# **PRELIMINARY/FINAL DRAINAGE REPORT FOR JUDGE ORR RANCHETTES**

October, 2017

PCD FILE NO's: SP-17-011  
SF-17-021

**PROPOSED DRAINAGE MAP**

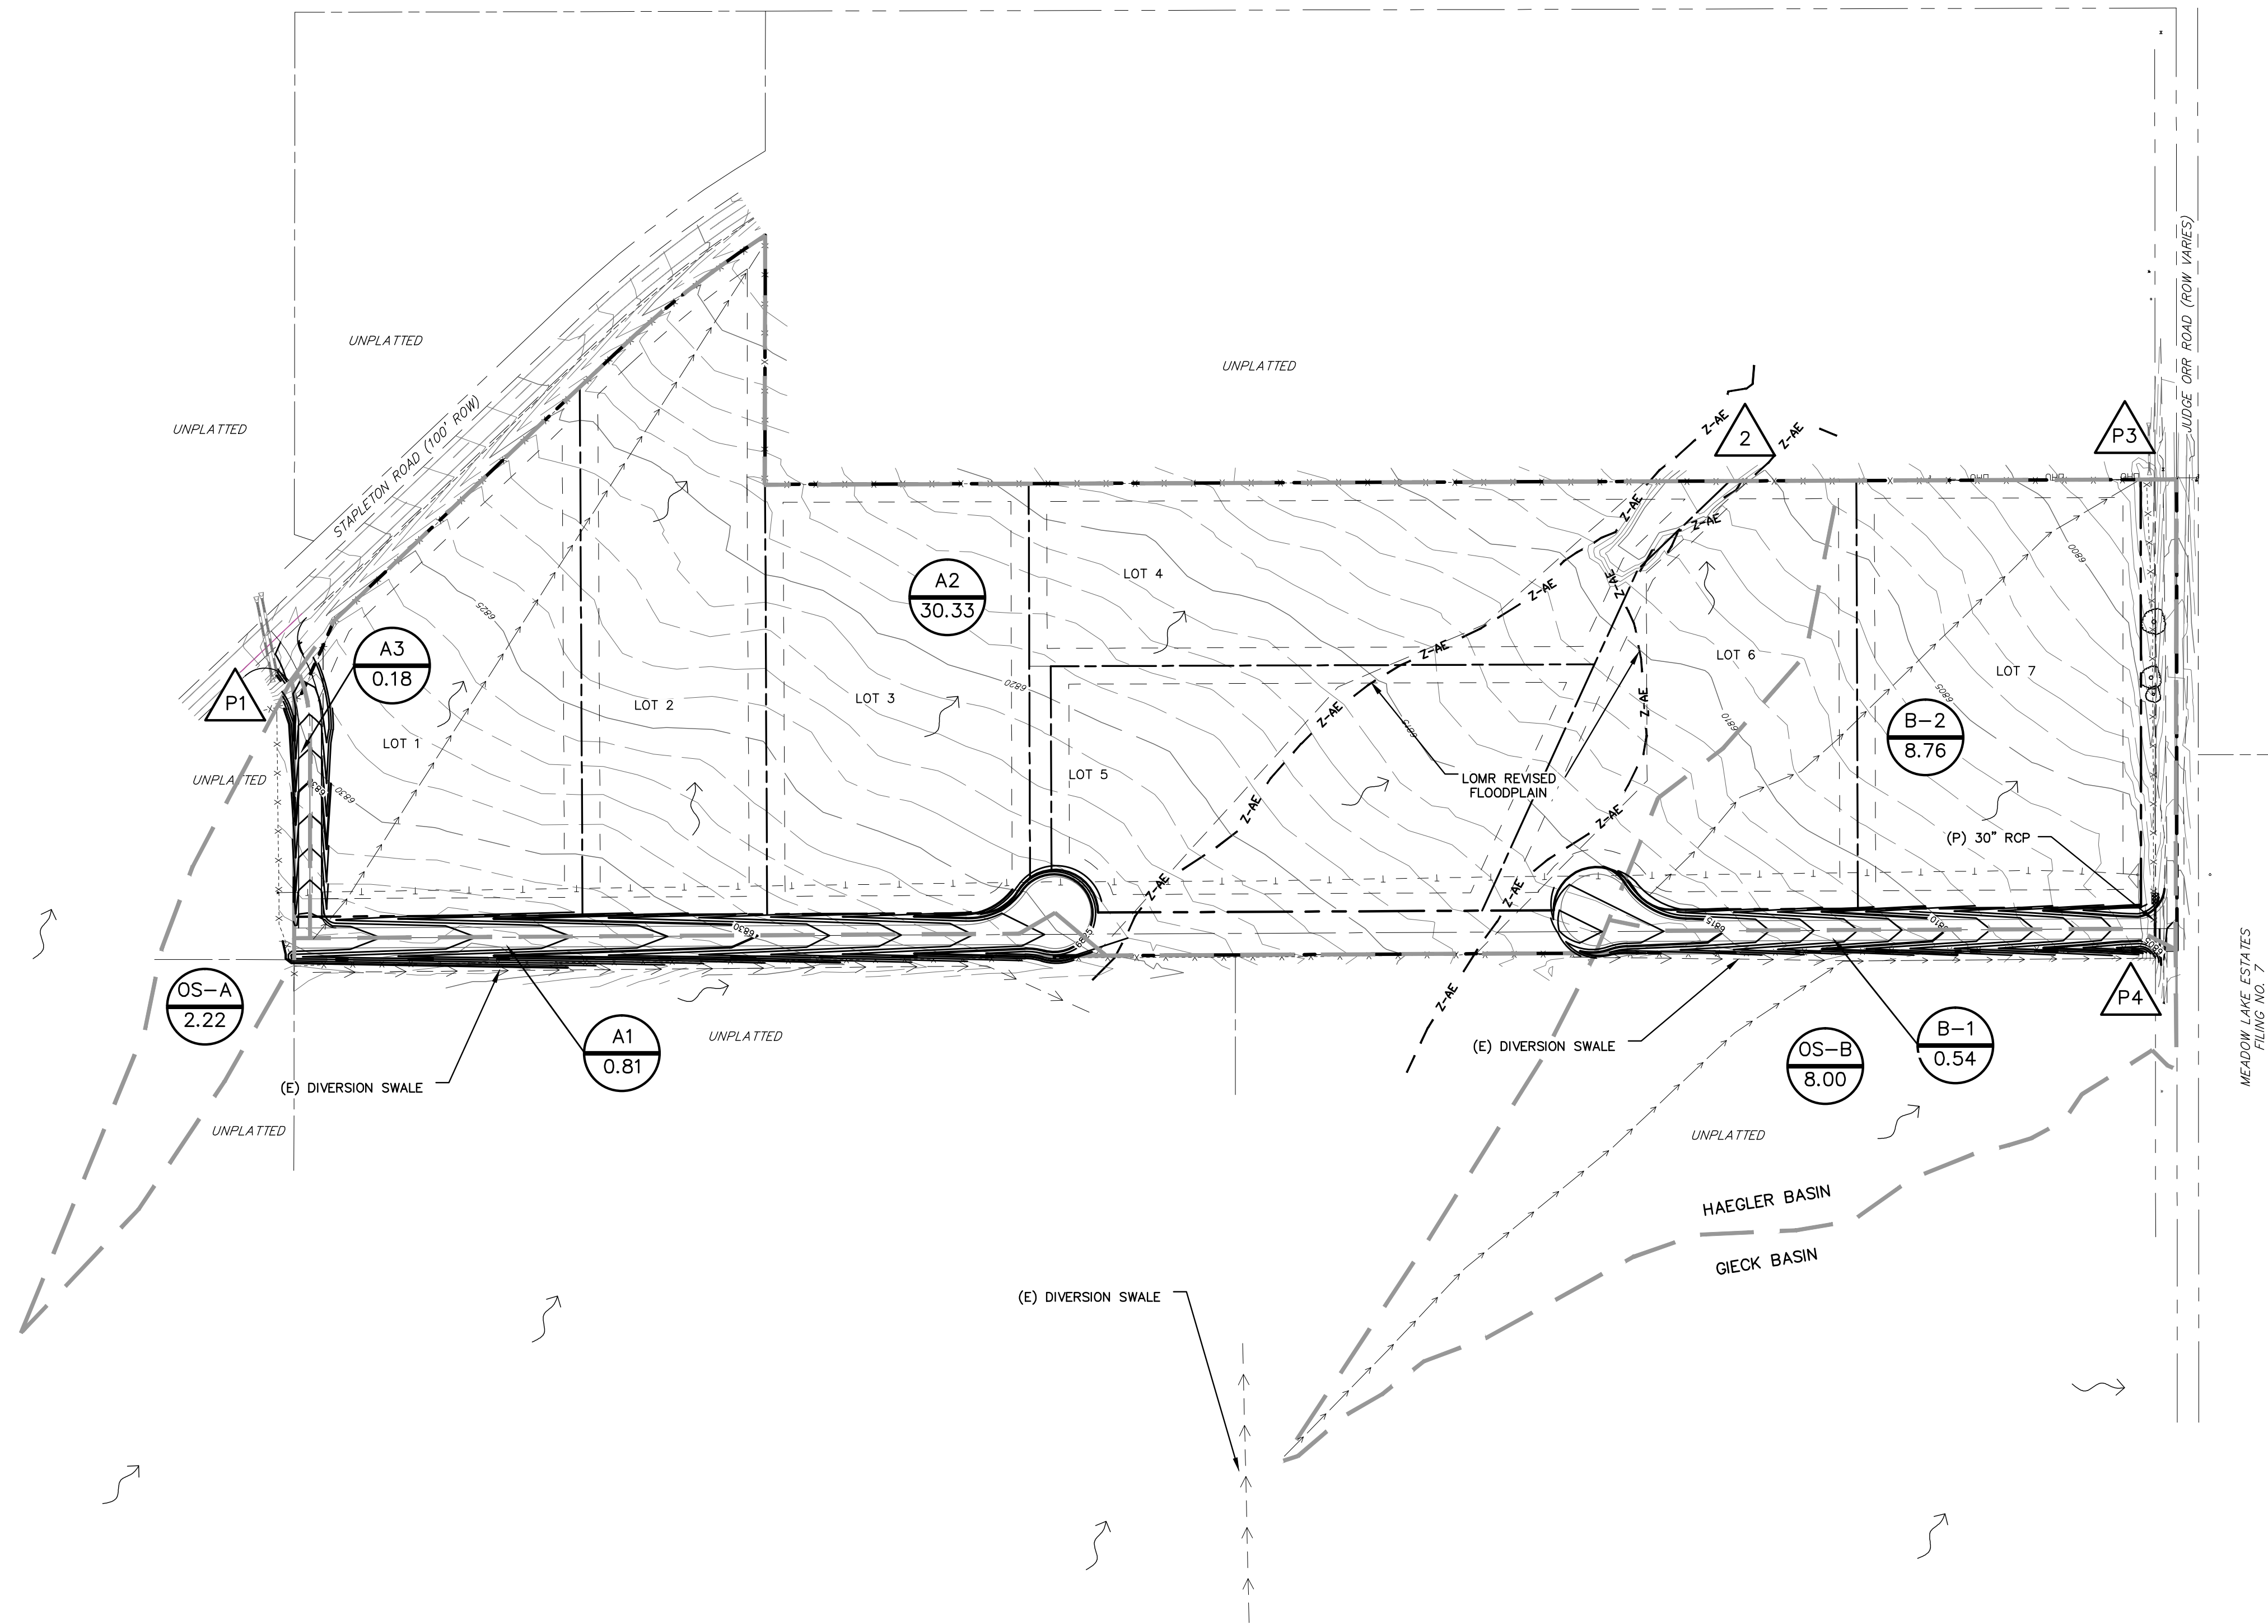
The drainage map shows an existing culvert at DP 3. Provide the calculation and analysis.
